WEST SUSSEX COUNTY COUNCIL CONSULTATION

TO:	Arun District Council FAO: Kathryn Welch
FROM:	WSCC - Highways Authority
DATE:	18 August 2021
LOCATION:	153 Elmer Road, Middleton-On-Sea, PO22 6JA
SUBJECT:	M/86/21/HH Rear single storey extension, garage conversion and new vehicle highway access and crossover.
DATE OF SITE VISIT:	N/A
RECOMMENDATION:	Advice
S106 CONTRIBUTION TOTAL:	N/A

PROPOSED PLOT PLAN

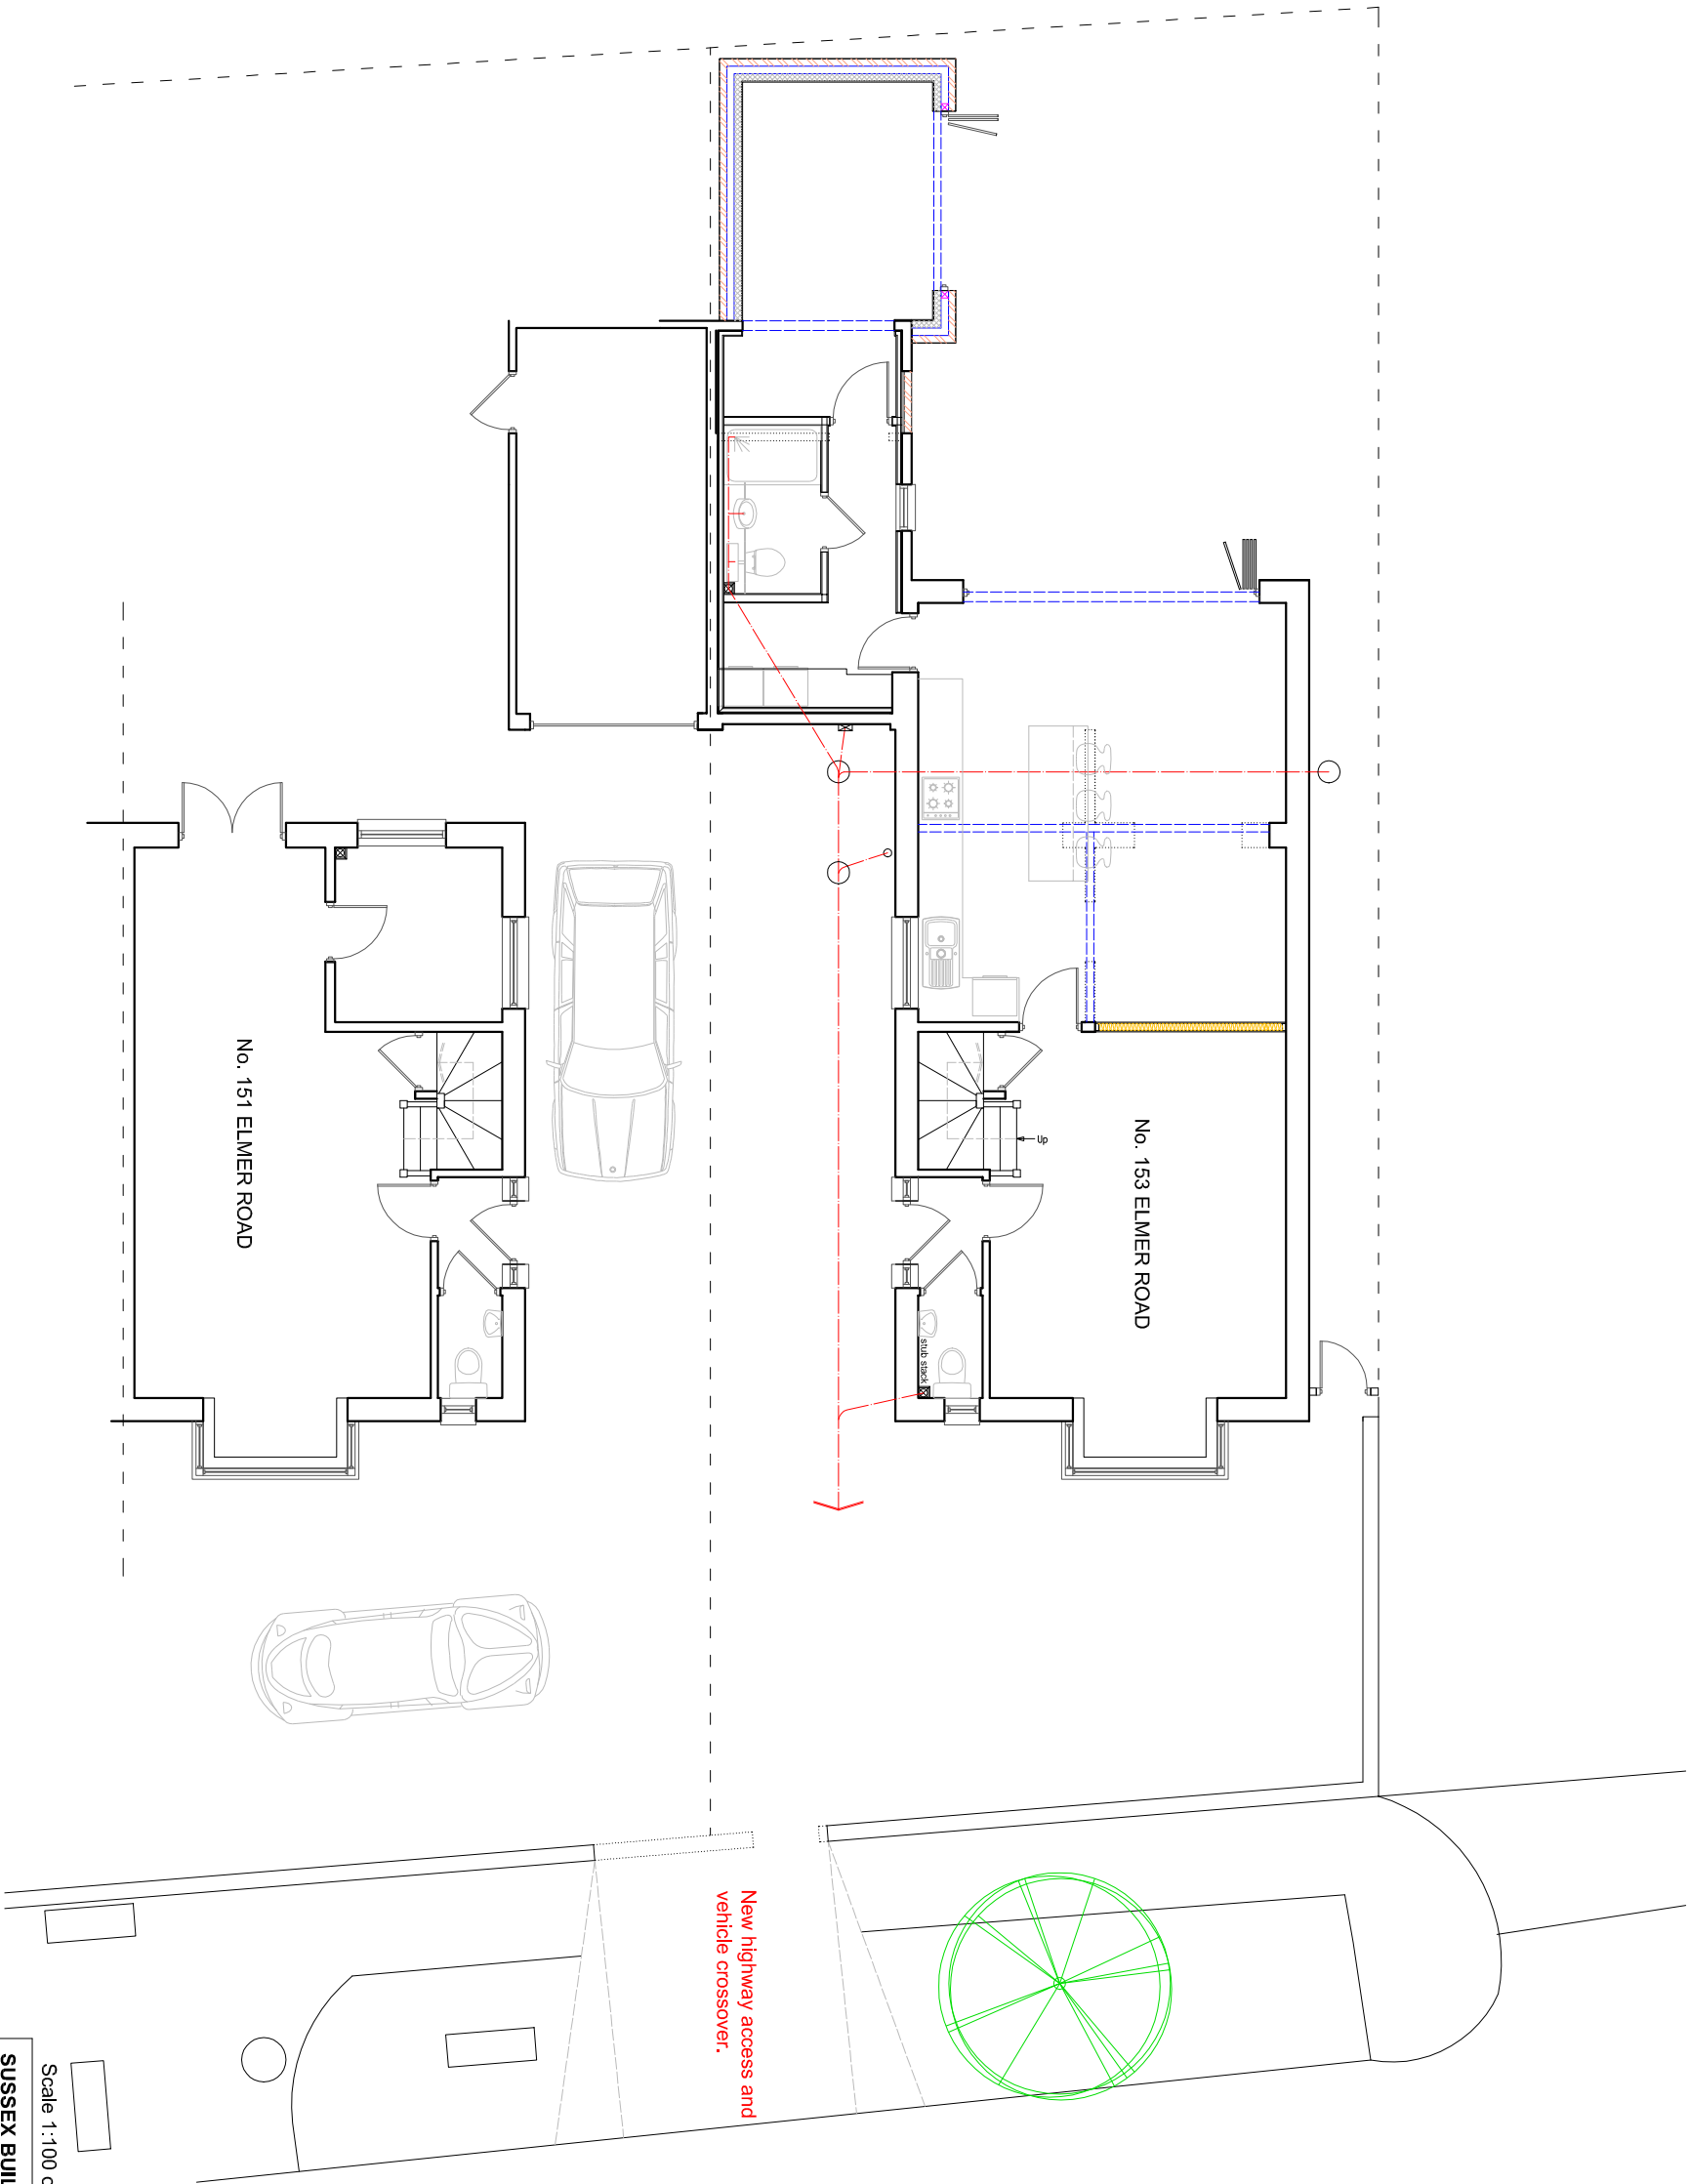
Regarding the proposed access, the applicant has demonstrated visibility splays of 2.4m x 43m in both directions, which is in accordance with the Stopping Sight Distances (SSD) for 30 mph roads as set out in Manual for Streets (MfS).

The proposed vehicle crossover (VCO) will be subject to a licence obtained through the local area office and constructed to a specification agreed with the local area engineer. The applicant should be aware that under current guidance, second accesses in urban and sub-urban areas are highly likely to be refused a licence. This is in order to maintain as much on-street parking as possible. However, it appears that the location of the proposed access is currently sided by double-yellow lines, which would prevent on-street parking in this location. Therefore, further dialogue with the area office may be required when applying for a VCO licence.

The LHA notes that there appears to be a utility cabinet close to the proposed VCO on publicly maintained highway fronting the application site. To implement the access point, the utility cabinet must be situated at least 1.5m from the location of the top of the ramped kerb of the proposed crossover. Therefore, the utility cabinet may need to be relocated. If the utility cabinet is required to be relocated, these relocation works will need to be agreed with the operators and relocated at the expense of the applicant. Alternatively, the access could be positioned to be at least 1.5m away from the utility cabinet.
